Application number: 2020/91919	
What is the application for?:	Demolition of existing supermarket and erection of block of 6 flats with associa
Address of the site or building:	The Co Operative Food, 19, Northgate, Almondbury, Huddersfield, HD5 8RX
Postcode:	M60 0AG

User comments

PROPOSED ELEVATIONS C & D

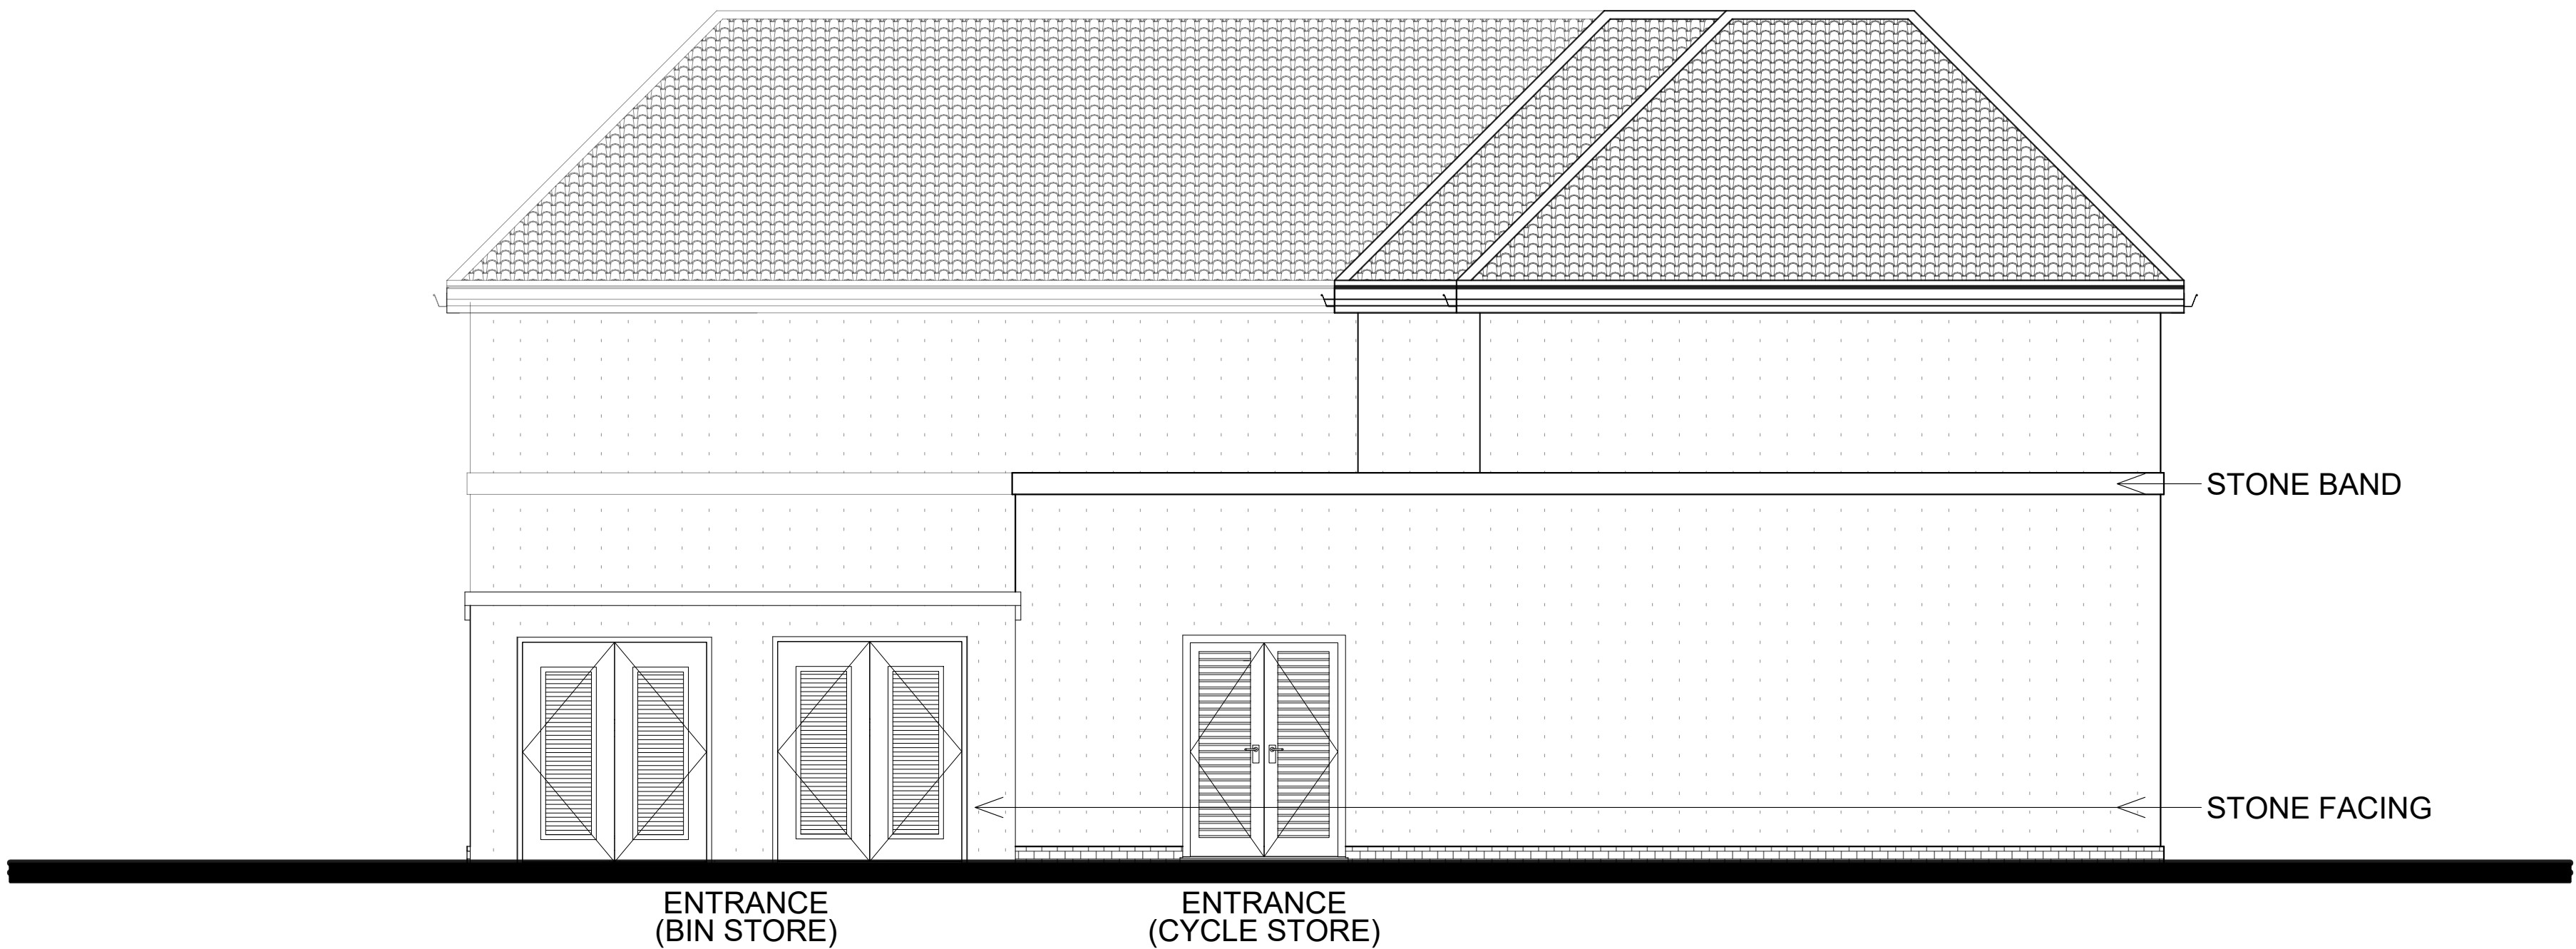
Type of comment: An objection	
Do you wish your comments to be published on the website anonymously?	No
<p>The plans are said to have been modified based on previous comments but this does not seem to have happened. The proposed building is still very near to my property and will block my light and impact negatively on my privacy - people will be able to see directly into my property and my garden, my only private outdoor space. The light blockage will be significant in my property as the building's elevation will be much taller than my property and very near to it. If the car park were put to the back and the property built with the front on the road (as noted in another objection) this would be much more suitable and in keeping with the village and much less impactful on surrounding properties. In addition, the number of proposed flats is a lot for the small space. If it were smaller, the proposed property would not be so squashed into the space causing it to be located so closely to neighbouring properties.</p>
